Application for a non-material amendment following a grant of planning permission.

Number	189
Suffix	
Property name	
Address line 1	Kingsway
Address line 2	
Address line 3	
Town/city	Hove
Postcode	BN3 4FB

Application for Variation of Conditions 1, 5, 6, 7 and 9 of BH2017/01108 (Erection of 5 to 8 storey building to provide 60no residential dwellings (C3) (mix of one, two, and three bedroom units) incorporating balconies and terraces with associated access from Sackville Gardens, 21no basement car parking spaces, 6no ground floor car parking spaces, cycle parking, plant and associated works) (amended by BH2019/03517 and BH2020/00355) to allow for changes to their wording and changes in balcony design.

1. Lengthening of access ramp to accord with building regulations requirements
2. Changing of sliding patio doors to two casement doors on fifth floor (plot 42)
3. Internal layout changes to units 10, 18, 26, 34 and 41 from 3-bed units to 2-bed units

Originator JMG/LW	Approved MK	Date 17.09.2019	Scale 1:200 @ A1
Drawing No. 5471-036	Rev. D	Sheet No. 1/1

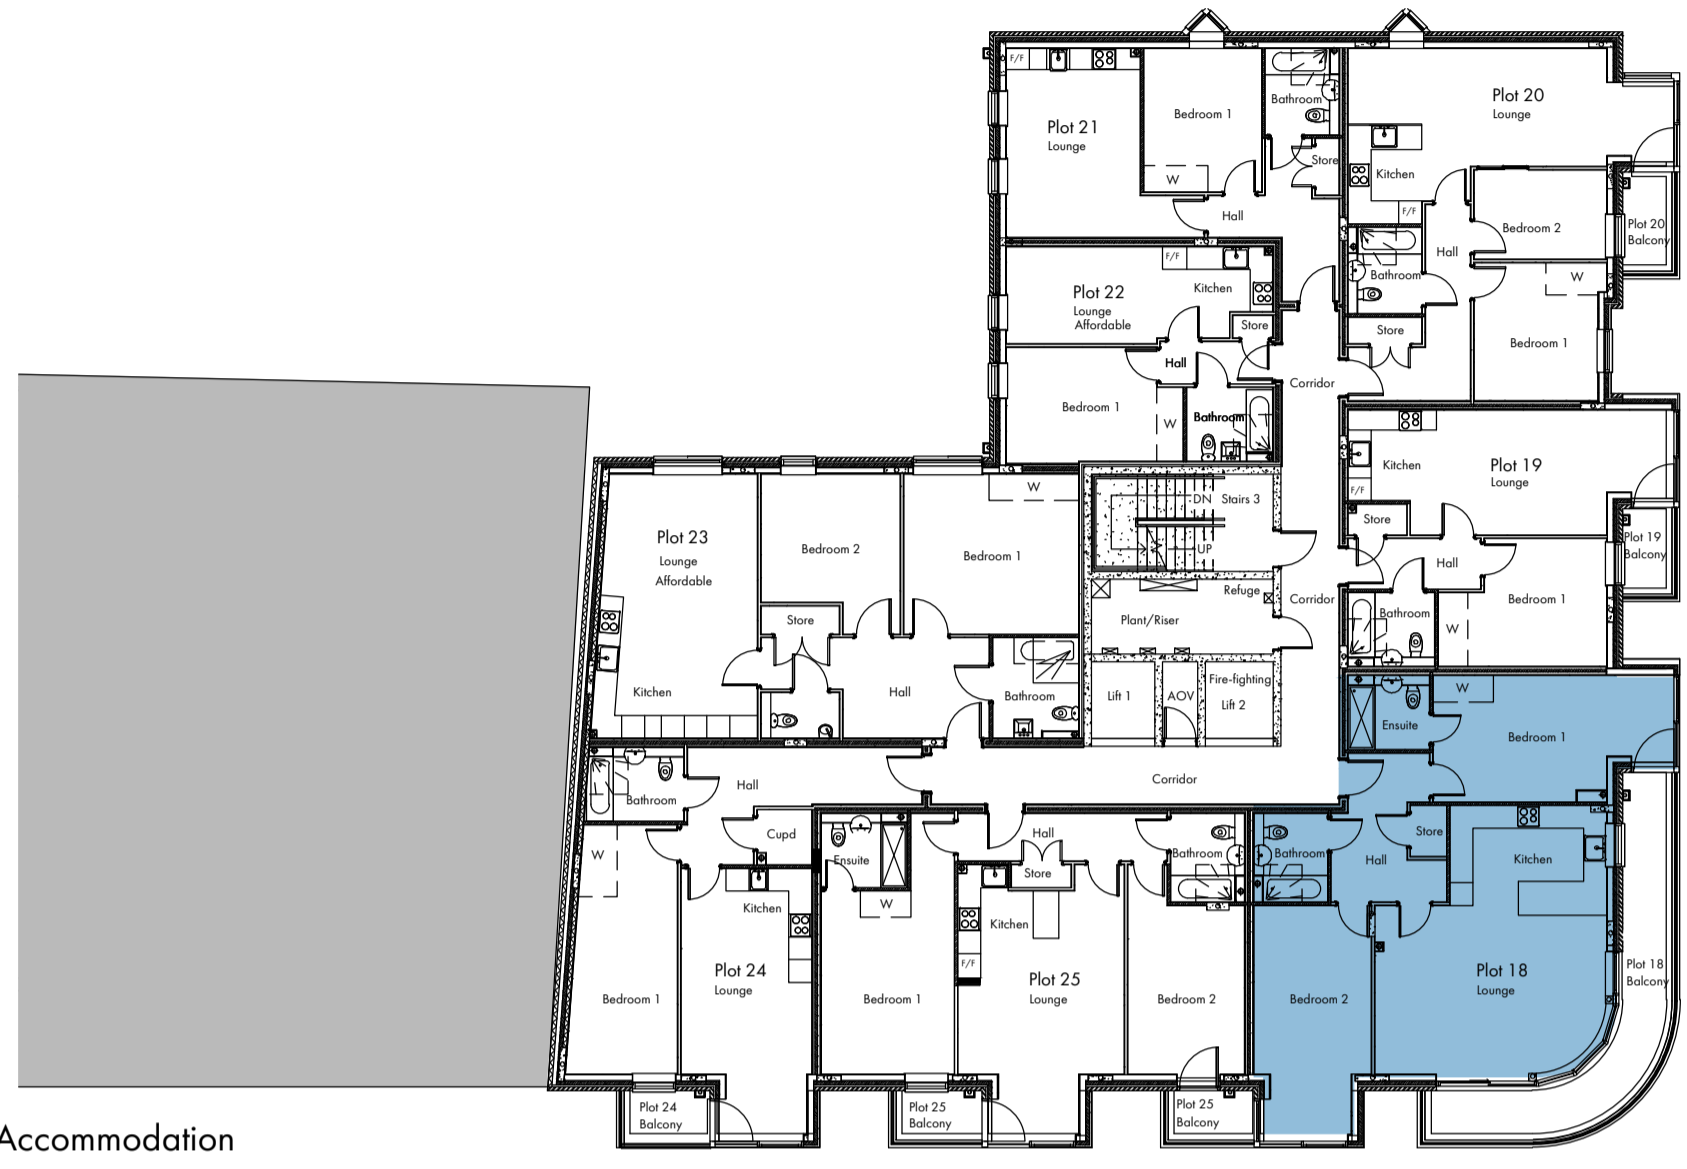
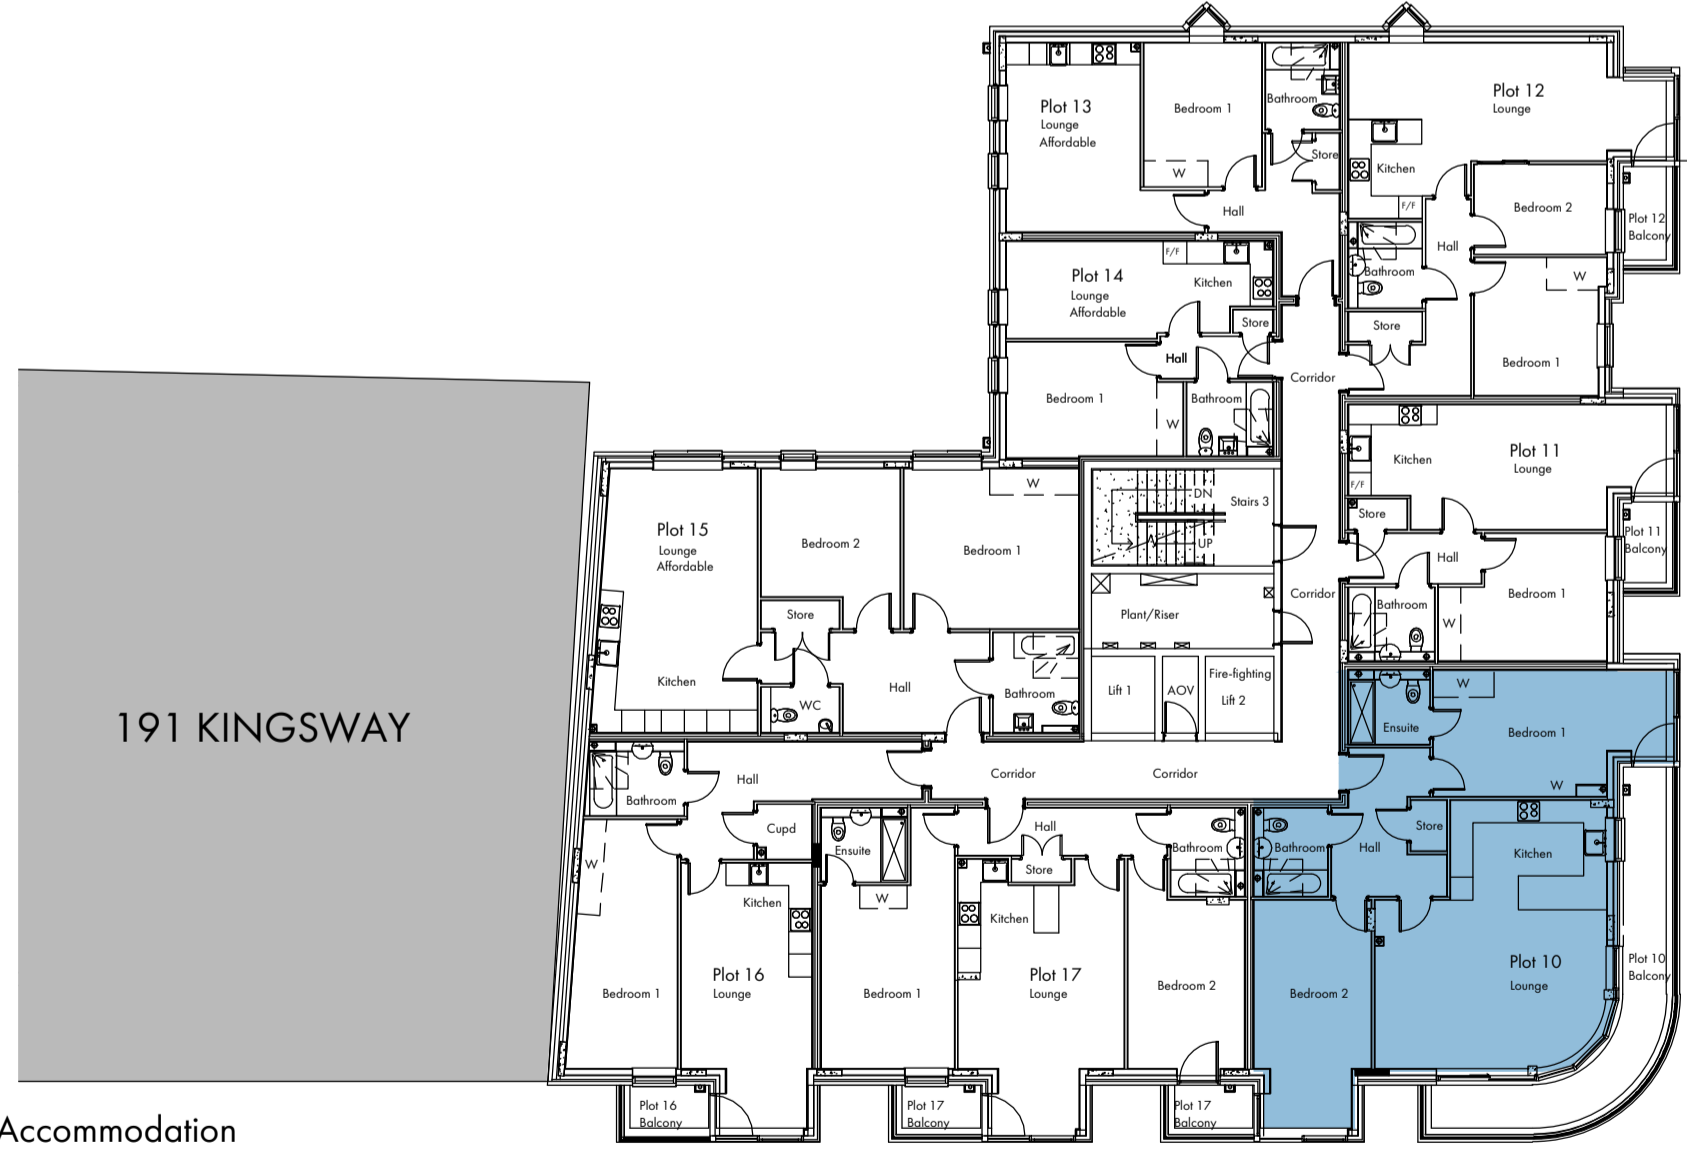
Prospective purchasers want 2-bedroom units with better kitchen/lounge areas. Casement doors to unit 42's patio requested by prospective purchaser
Lengthening of access ramp required by building regulations.
